**REQUEST**

Current Zoning: N1-A (neighborhood 1-A)  
 Proposed Zoning: UR-2(CD), 5-year vested rights (urban residential, conditional)

Approximately 53.07 acres located on the east side of Elm Lane and west side of Rea Road, south of Bevington Place.

The petition proposes to develop a residential community containing multi-family, single family attached and detached dwellings on the site currently developed with one single family dwelling in south Charlotte.

**RZ-3**

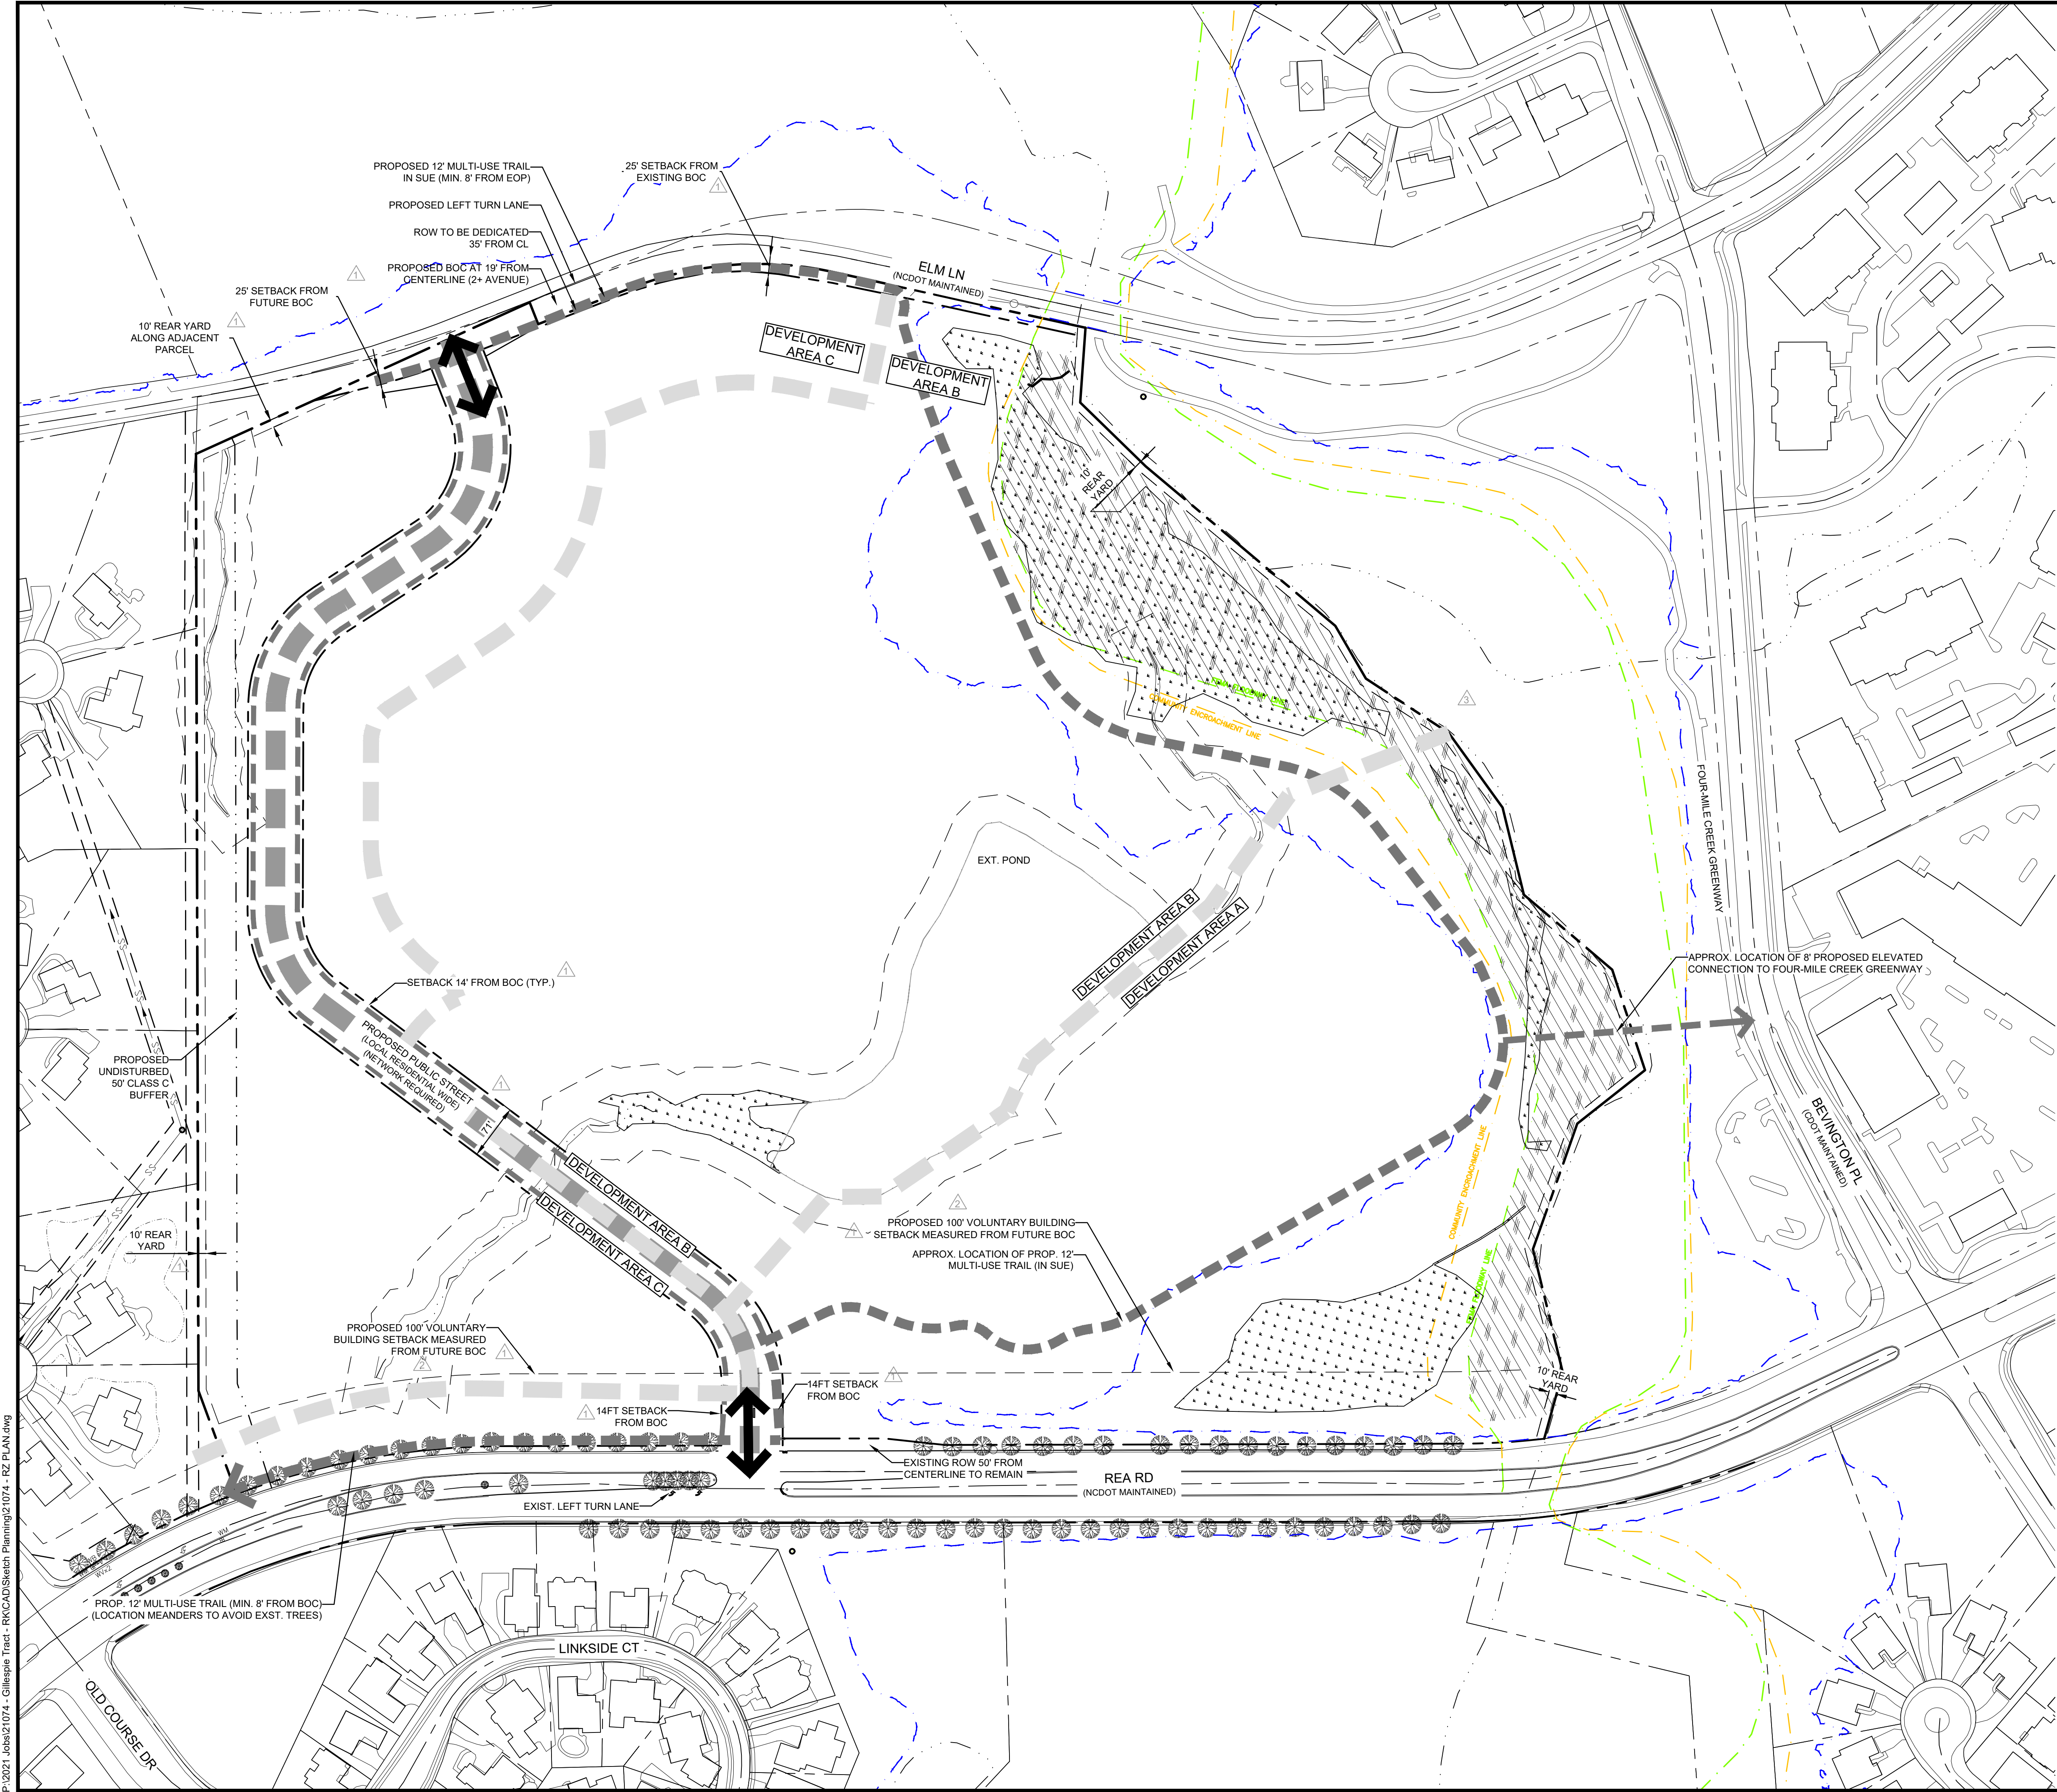
2. Commit to screening of parking areas adjacent to the streets and the internal MUP, see multiple areas identified on site plan comments.
3. Reorient the building between the Pvt Alley and Rea Rd. south of the proposed street so that fronts Rea Rd.

4. Relocate proposed parking area at the southeast corner of the intersection of Elm Ln and the proposed public street so that it is internal to the development.

5. Relocate proposed parking area at the northwest corner of the intersection of the proposed public street and Pvt Alley so that it is internal to the development.

6. Clarify how pedestrian connection will be made from Rea Rd. to the proposed internal 12' multi-use path.
7. Remove/modify notes 3.2.3 and 3.2.4 to clarify that additional multi-family units would not replace single family attached units shown on the plans.

8. Update notes for development areas to align with what is shown on the plans. Development area C shows less than 91 units and overall unit count appears to add up to 646 not 640 as proposed. Update notes to provide a max unit number for all development areas.
